Subject: RE: Planning Consultation on: AB/136/21/PL

Engineers Comments Regarding Surface Water Drainage

Application No: AB/136/21/PL

Site Address: Land Adjacent 18 Queens Lane Arundel BN18 9JN

Figure 5.3 – Modelled flood extents for the 'defended' 1 in 200 year return period event including an appropriate allowance for climate change. Site boundary delineated in red.

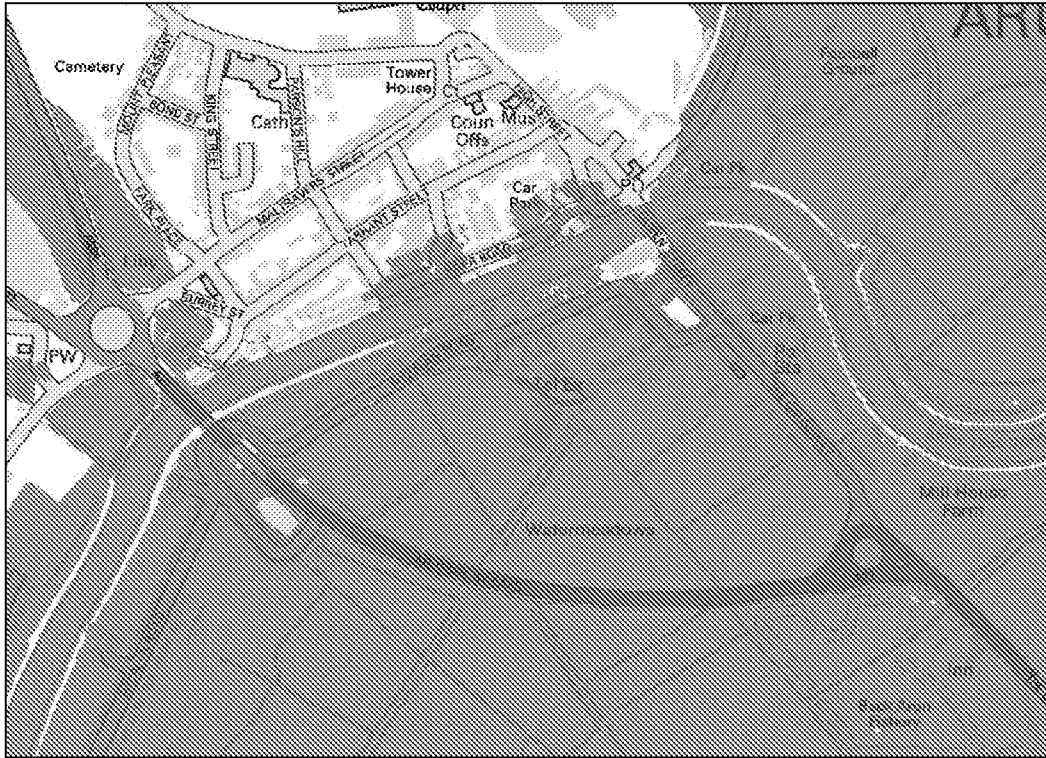
It is worth highlighting that in a defended scenario the flood levels for a 1 in 200 tidal flood event vary from 1.2m to 2.3m (2.05m at the buildings) in depth on the site. The FRA acknowledges that dry and safe access and egress will not be available in this event, paragraph 154 of the NPPF states that new development should be planned for in ways that: avoid increased vulnerability to the range of impacts arising from climate change. This proposed development does not appear to do that.

The FRA argues that compensatory flood storage would not be required, we would dispute this. The construction of the new dwellings within the floodplain has the potential to displace water and to increase risk of flooding elsewhere.

Figure 8.2 – Indicative drainage layout plan showing the proposed location of SuDS.

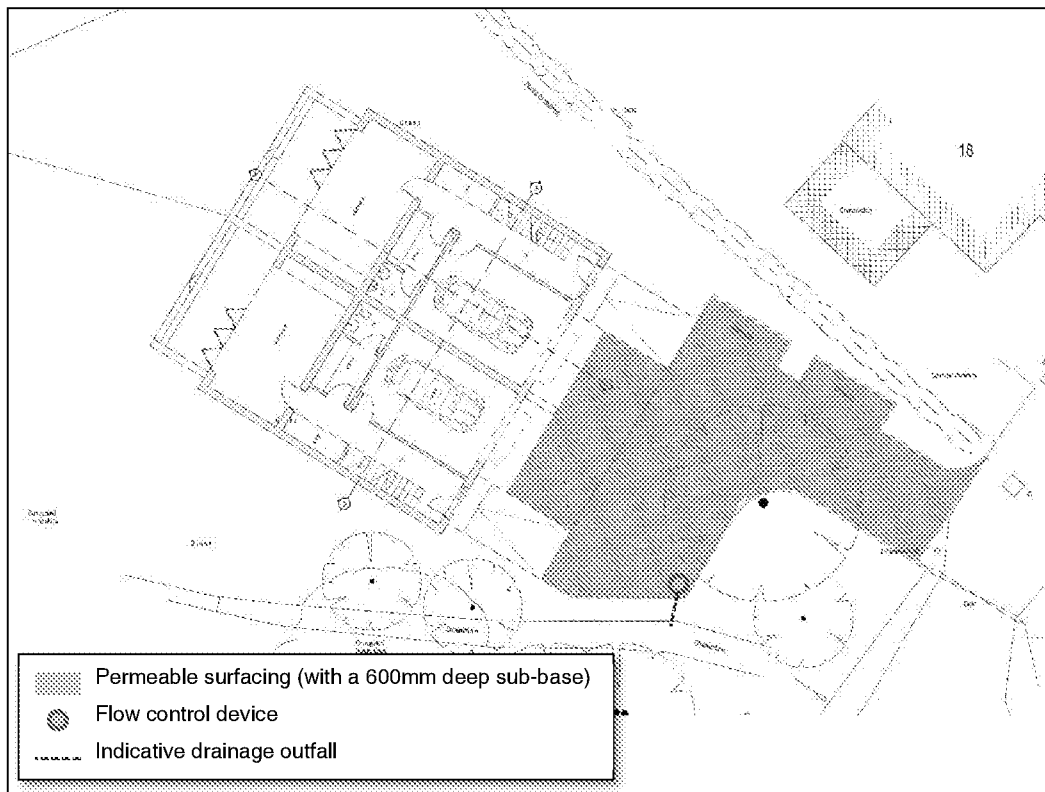
As the site is wholly located within Flood Zones 3a and 3b, designing a sustainable surface water drainage system will be challenging. SuDS should not be located in functional flood plain and we avoid locating SUDS in Flood Zone 3 as the drainage features will likely become inundated with fluvial water and in this case tidal flood water.

No groundwater monitoring has been undertaken for the site, however we would expect groundwater to be high and this will influence flood risk and the drainage strategy. The applicant should be aware that we expect a climate change allowance of 40% (not 30%) to be applied to rainfall intensity. An Activity Permit will be required from the EA to connect flows to this watercourse as it is located in an Internal Drainage District (IDD).

In order to overcome my objection the FRA would need to be updated to account for the omissions and discrepancies described above. Furthermore, I would expect all surface water drainage design to be agreed prior to determination, with appropriate winter groundwater monitoring and infiltration testing. The surface water drainage design would have to show that flooding would not be increased on-site or off-site for the lifetime of the development with appropriate allowances made for climate change and urban creep.

Map showing 18 Queens Lane, Arundel and the extents of Flood Zone 3b.

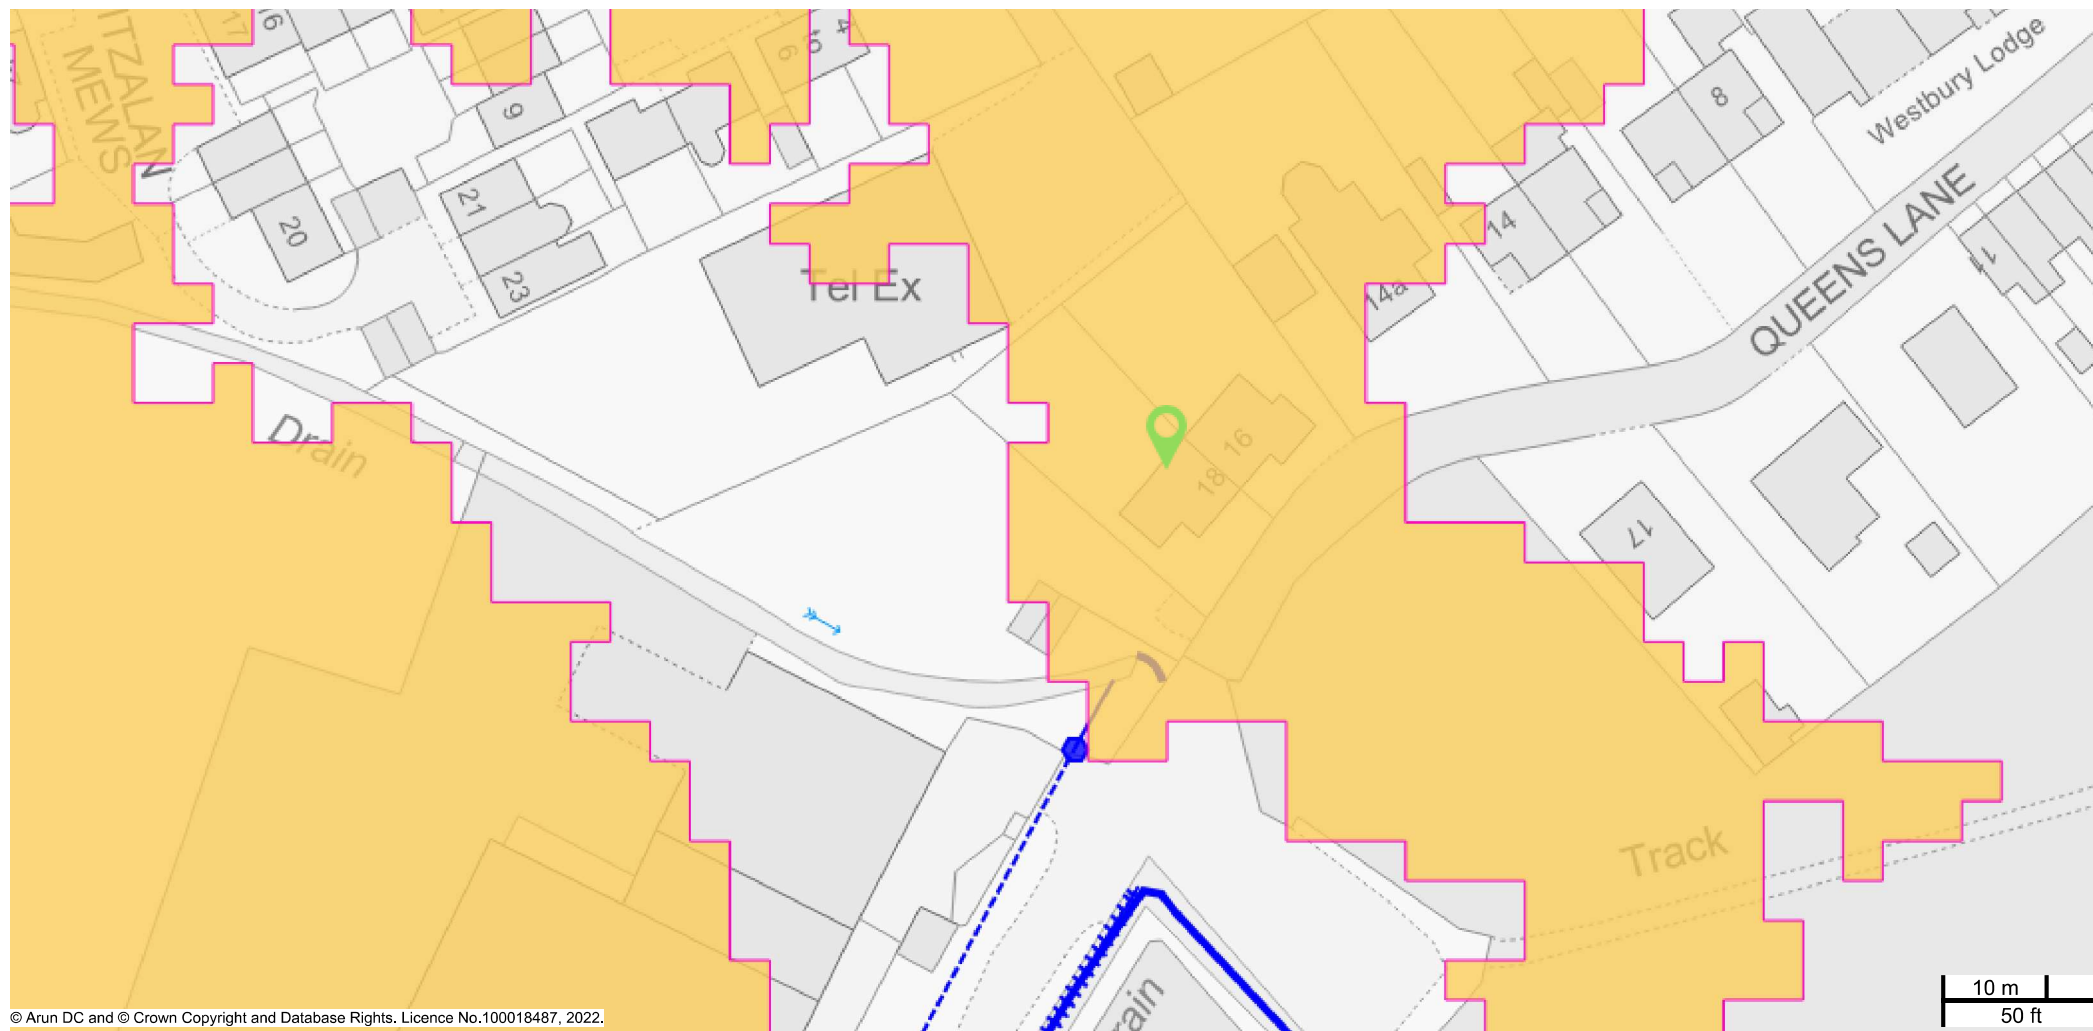
The FRA for this application appears to have significant omissions and errors. Part of the application site (where part of the proposed dwelling is proposed) appears to be classified as functional flood plain Flood Zone 3b ([Arun SFRA mapping](#), sheet 45 of 46).

I have also attached a map which clearly shows that the east and south-eastern corner of the site are within the extents of Flood Zone 3b. Please ensure that the Environment Agency (EA) are made aware of this. Please also consider that this is land "where water has to flow or be stored in times of flood. This zone is generally defined as the land which would flood with an annual probability of 1 in 20 (5% AEP) or greater in any year" (this is the case for the Arun District). Only water-compatible uses and the essential infrastructure that has to be there should be permitted. As the development is for "More Vulnerable" use as a dwelling house, [Table 3 Flood Risk Vulnerability and Flood Zone 'compatibility'](#) shows that **development should not be permitted.**
